Recommendation Report for Planning Permission for Works or Extension to a Dwelling

REF NO: R/85/21/HH

LOCATION: 9 Cove Road
Rustington
BN16 2QW

PROPOSAL: Erection of part single and part two storey rear and side extension, garage conversion and alterations to fenestration/openings following the demolition of existing rear conservatory.

EXISTING AND PROPOSED GROUND FLOOR PLANS
PROJECT – INTERNAL ALTERATIONS AND EXTENSIONS

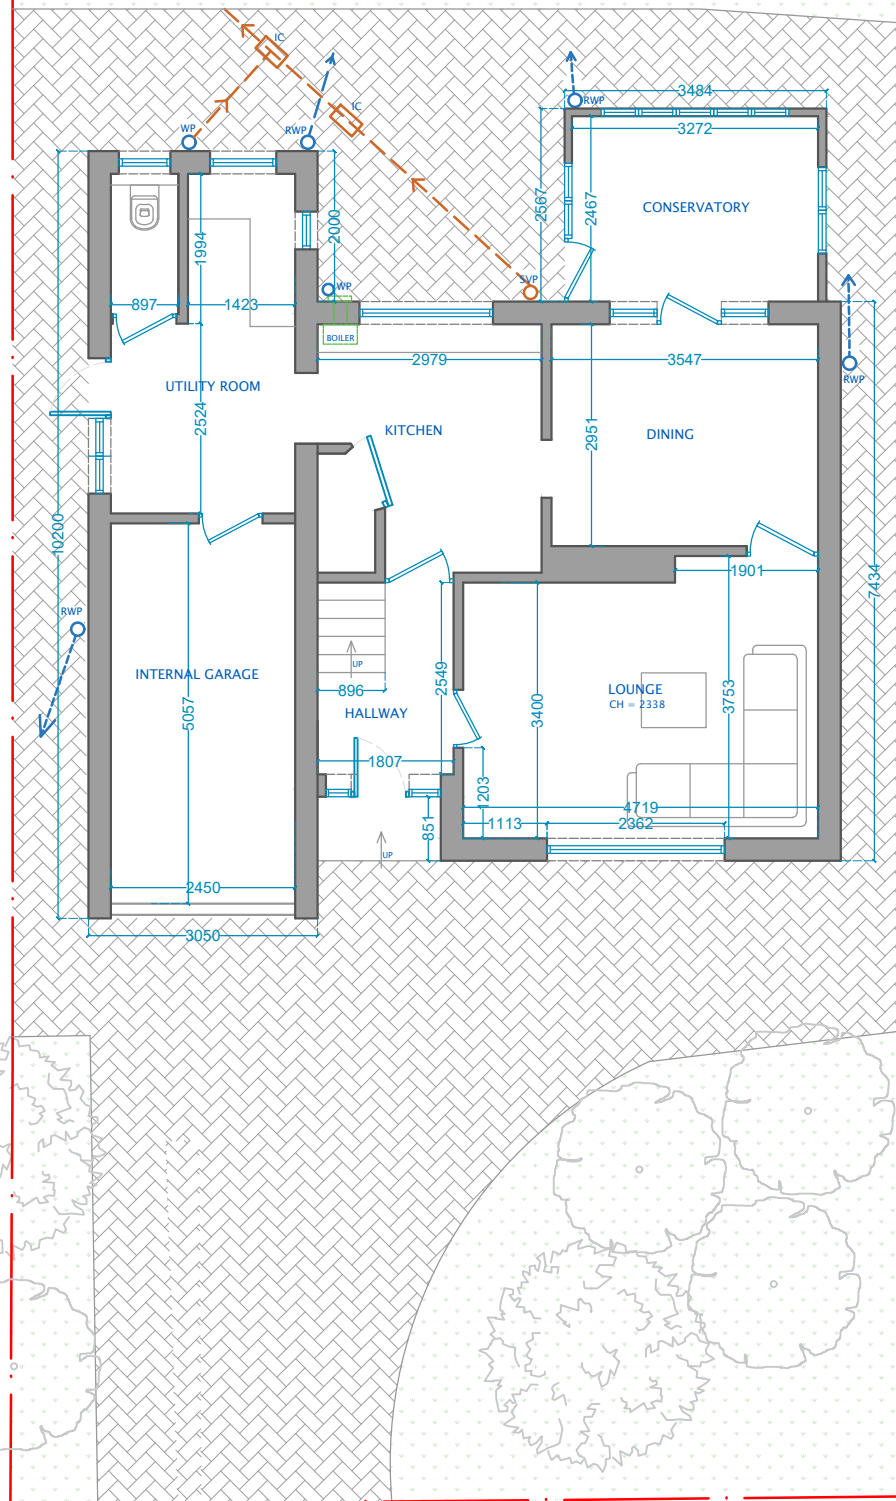
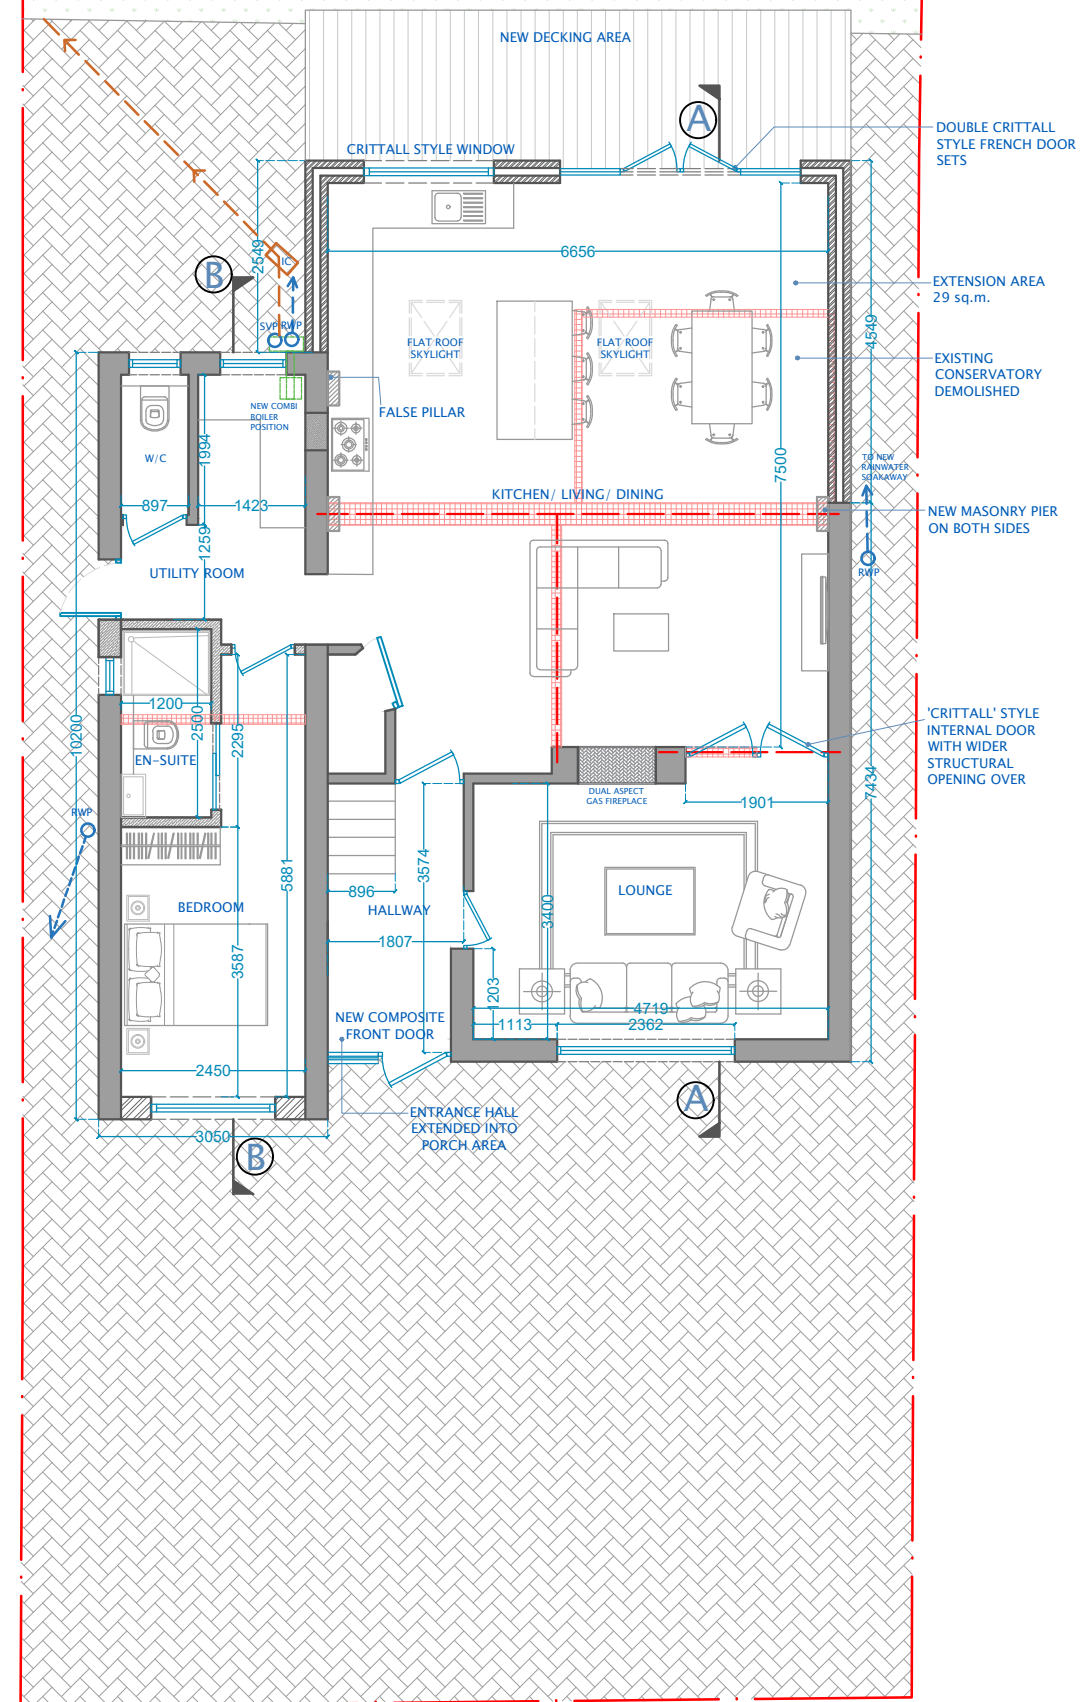
The part two storey rear extension is limited in scale and approximately measures (2.78m in depth). The existing single storey extension measures 2.36m in depth and overall depth of the extension would measure 4.26m and height is below 3m with flat roof. However, up to 4m could be built under provisions of the permitted development.

Garage conversion into habitable use would result in loss of f parking. The front driveway could facilitate additional parking space. Proposal complies with T SP1 of the Arun Local Plan.

FRONT ELEVATION - PROPOSED

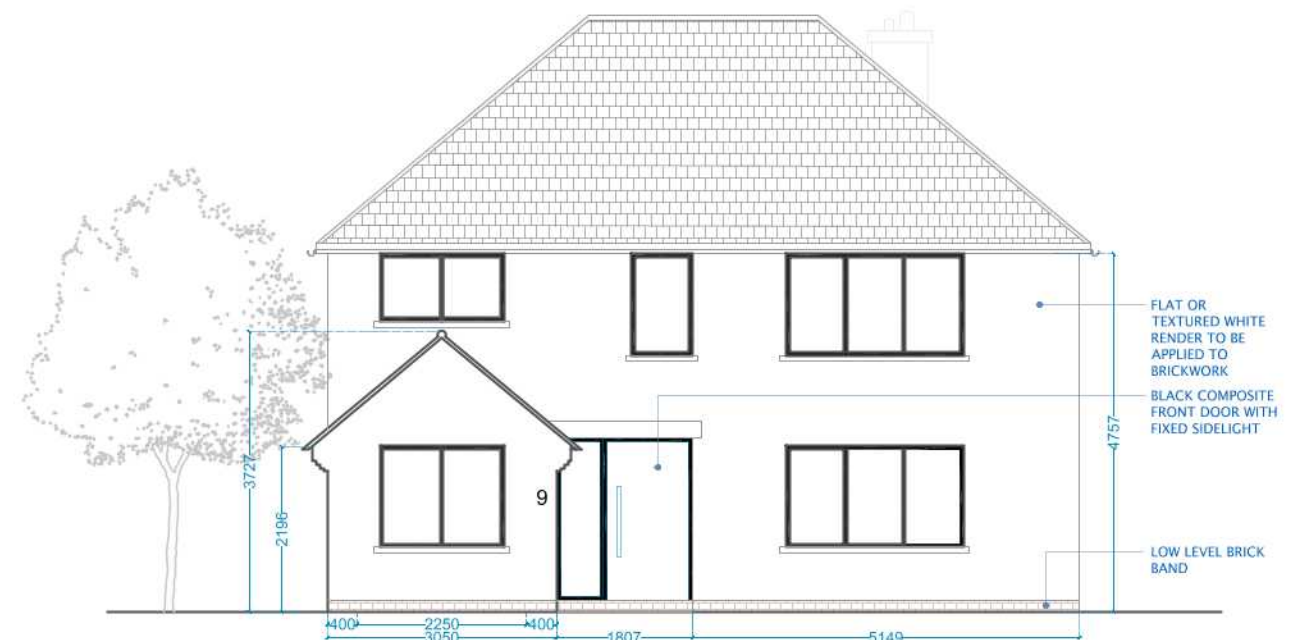
The side extension which would be built above the garage and the roof profile would be altered incorporate a hipped roof. The development, whilst large, blends in with the built form of the dwelling. The proposal involves alterations to the fenestration pattern and removal of the garage door and insertion of a window.

The proposal does conflict with advised contained in Class M of the Design Guide because the side extension is built flush with the host dwelling; however this does not significantly alter the appearance nor it creates an terracing effect. It is noticed that street scene is characterised by similar types of alterations and extensions, the proposed development is not considered to have significant harm on the visual amenity of the street scene. The side extension and alterations would uplift the dwelling to provide more contemporary appearance which is supported by class M of the design guidance and NPPF. The part rear single rear extension would not visible from the public domain and therefore development would have lesser impact on the street scene. The existing materials are standard brick finish and rendered white finish has been proposed. Brisk finish and rendered finish is quite prominent finish within the street and some properties contain both.

SITE PLAN - EXISTING AND PROPOSED	REVISION B	04.04.2021	(Client Review)
PROJECT - INTERNAL ALTERATIONS AND REAR EXTENSION	REVISION C	15.04.2021	(Planning)
	REVISION D	23.04.2021	(Planning)

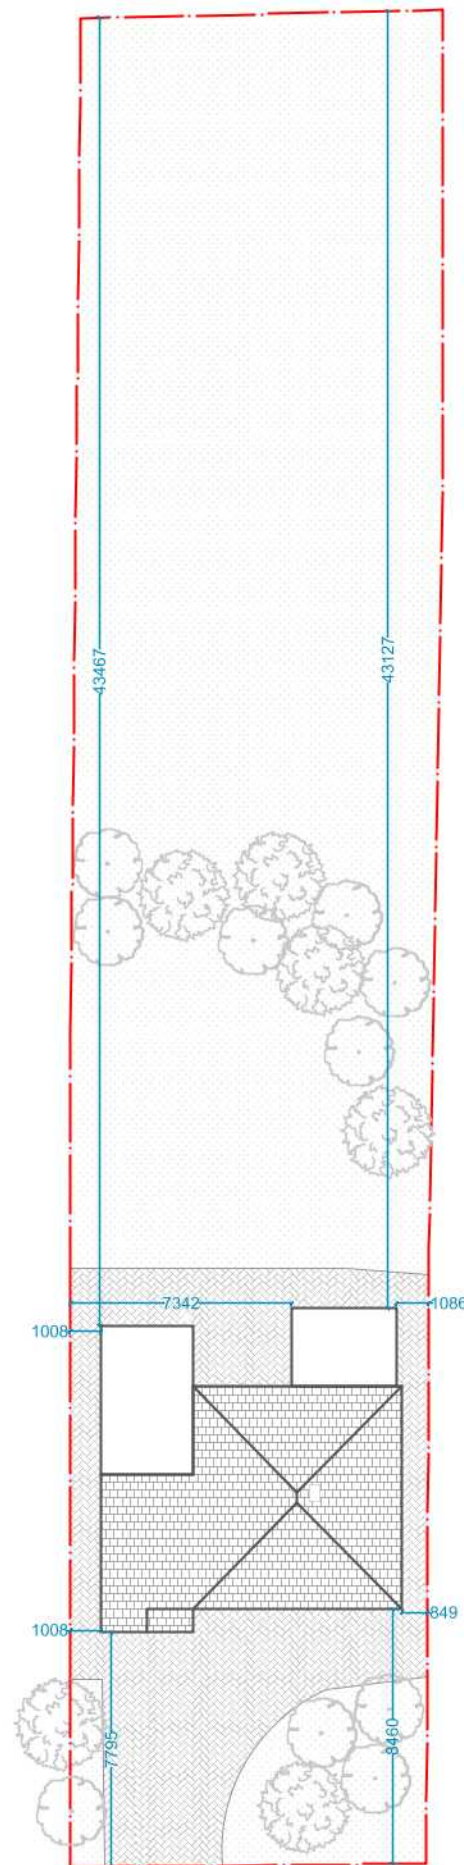
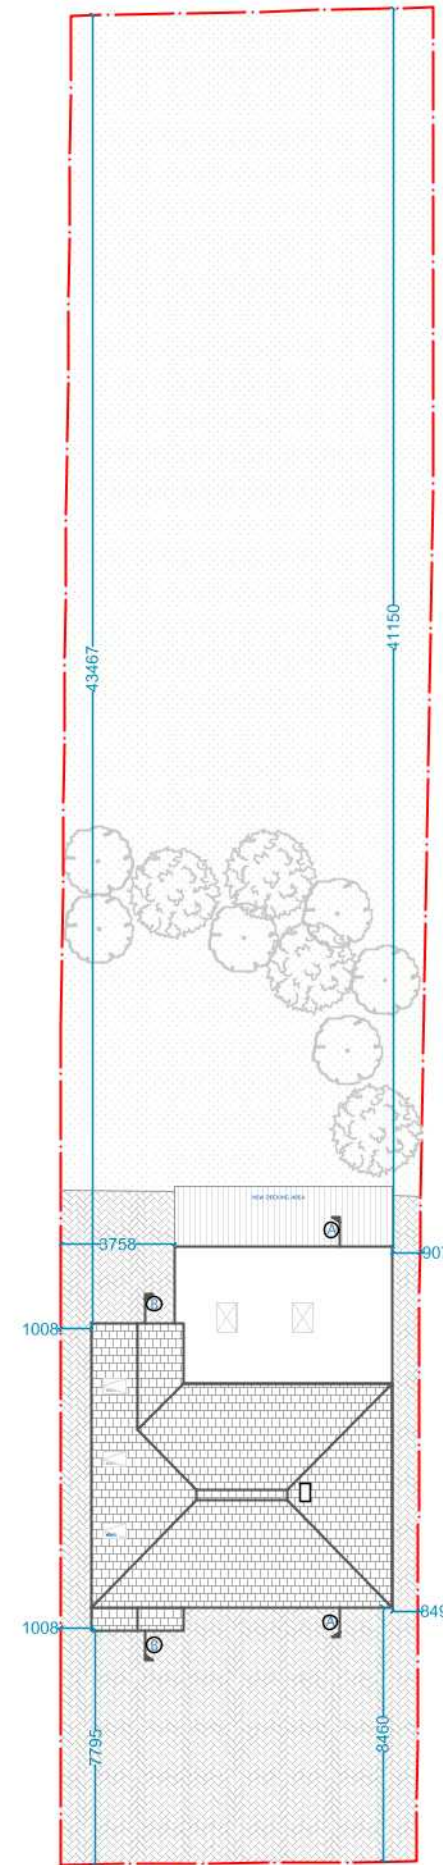
In this case development does conflict with the class M design guide; whilst the refusal cannot be justified. The 45-degree line has been shown on the plans which does not indicate any loss of light or overbearing impact on the adjoining dwelling. The detached nature of the plots and distance from the boundary helps mitigate impact of the development. Therefore, no demonstrable harm is demonstrated to residential amenity. The development is not considered to harm neighbouring amenity by way of overbearing, overshadowing or overlooking and accord with D DM1 and D DM4 of the Arun Local Plan.
